From: Martyn White <Martyn.White@arun.gov.uk>
Sent: 12 July 2021 16:32
To: Planning.Responses <Planning.Responses@arun.gov.uk>
Cc: Anita Gardner <Anita.Gardner@arun.gov.uk>
Subject: LU/136/21/PL

LU/136/21/PL

Mewsbrook House 59 East Street Littlehampton BN17 6AU

Second & third storey extensions to existing care home to provide 14 No. new residential care rooms. This application may affect the setting of listed building, may affect the character & appearance of the East Street Conservation Area & is in CIL Zone 4 (Zero Rated) as other development

DRAWN BY: EL
DATE: 5TH FEB 2021
DRAWING TITLE: PROPOSED SECOND FLOOR PLAN
SCALE: 1:100 @ A1
DRAWING NO: P203

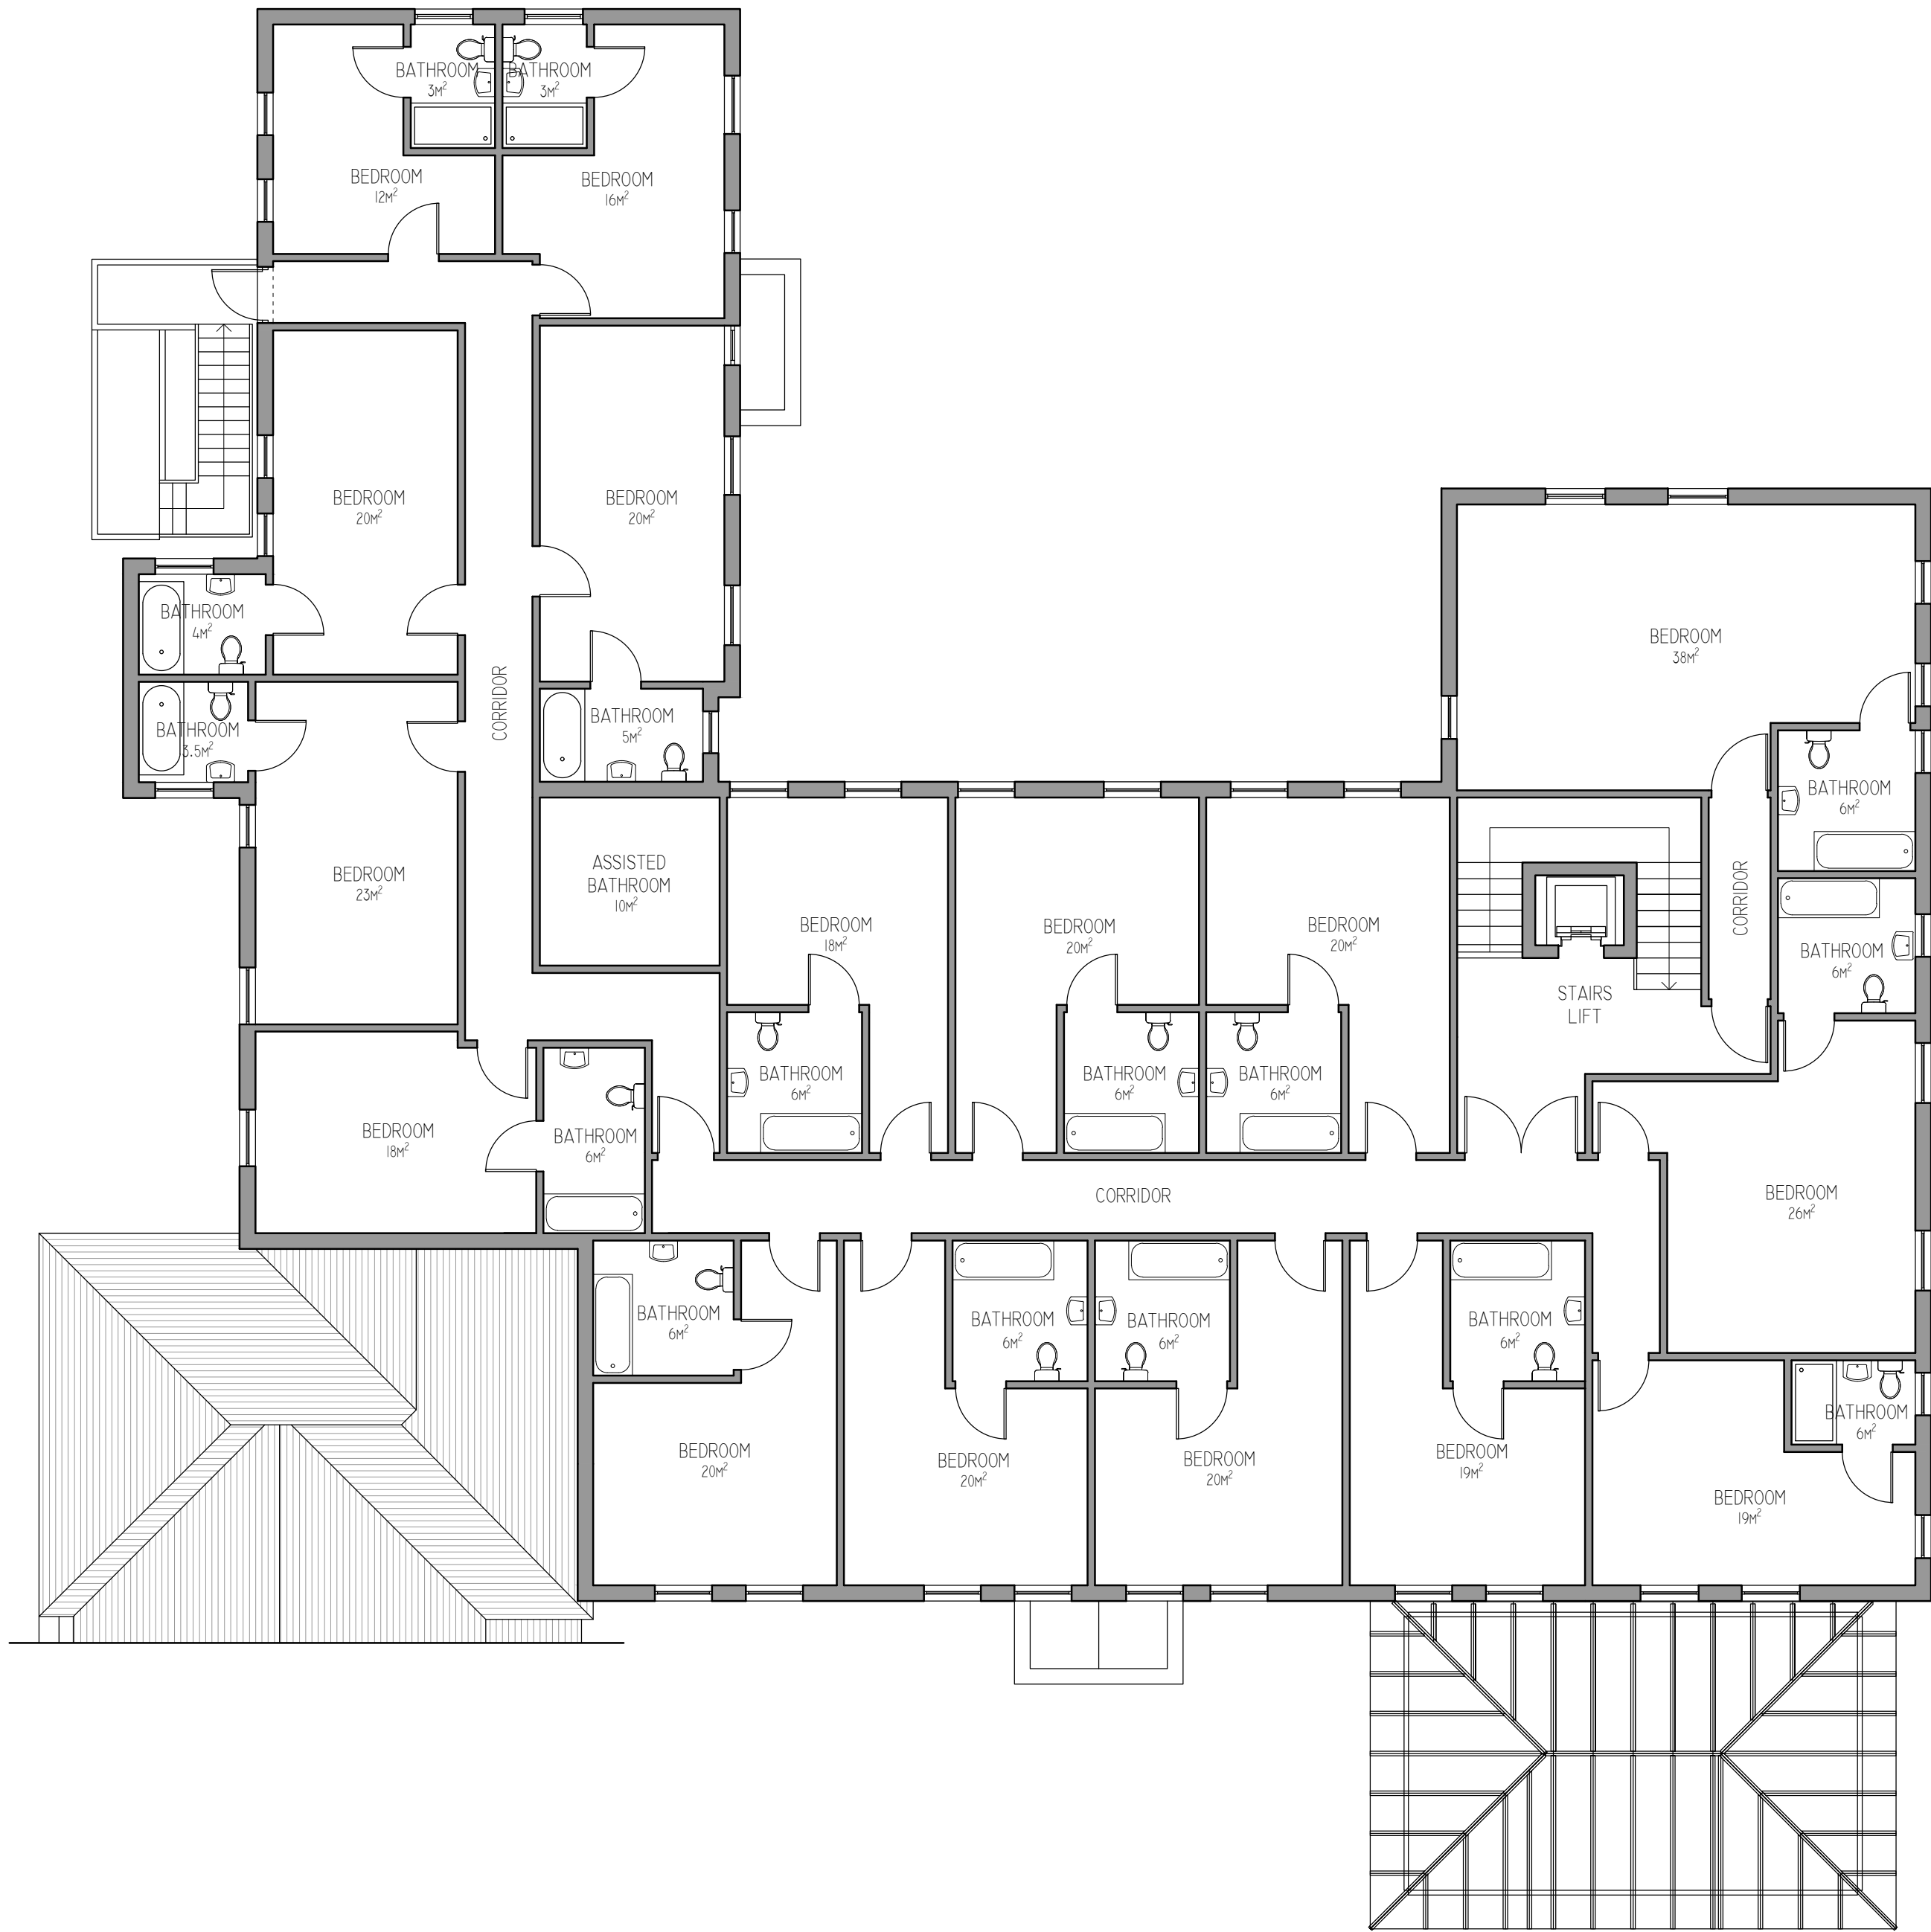
Whilst the application identifies that the intention is to construct second and third storey extensions to existing care home, the plans indicate that only a second floor would be constructed (subject to gaining consent).

Therefore, I read the proposal as being for an additional floor as well as internal alterations. It would appear that the reason is to provide more and improved accommodation for the existing use.

The extension would have the same number of floors as the listed building with a higher eaves and roofline. The result will be an extension that is both larger in scale and height, and no longer subservient to the main listed building. This along with the existing large footprint would mean that it would dominate the listed building. The additional floor would therefore detract from the prominence of the listed building.
